Application for a non-material amendment following a grant of planning permission.
Town and Country Planning Act 1990

APPLICATION REF: 2016/1226 DATED: 22/02/17
ERECTION OF SINGLE STOREY EXTENSION TO REAR OF BUILDING.

- CHANGES TO EXTERIOR DOOR AND JULIET BALCONY TO BEDROOM - NOW WINDOW.
- CHANGES TO BLOCK UP SMALL WINDOW FROM KITCHEN AND ONLY PARTIALLY BLOCK UP EXISTING REAR DOOR TO PROVIDE LARGER WINDOW TO KITCHEN.

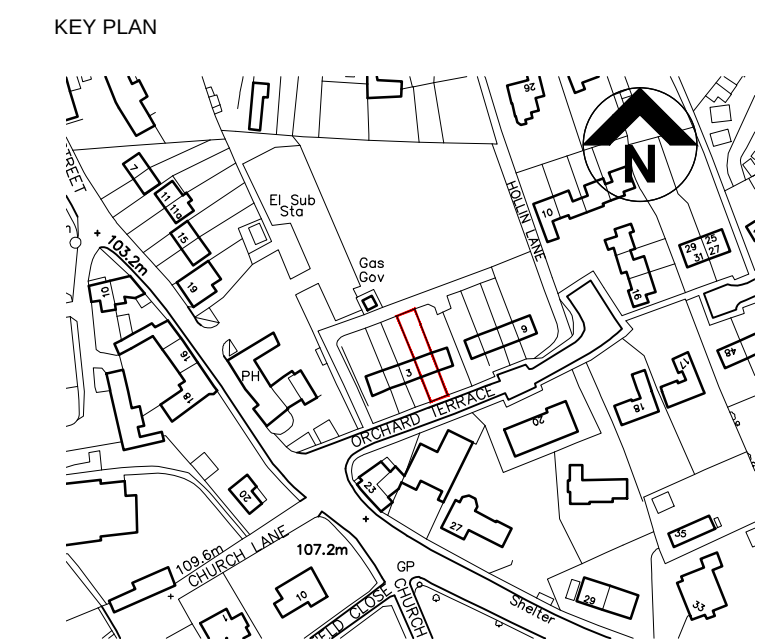
TO PROVIDE FURTHER LIGHT INTO THE KITCHEN, ALLOW WALL SPACE FOR EXISTING ELECTRICAL DISTRIBUTION AND PROVIDE MORE SPACE IN THE BEDROOM.
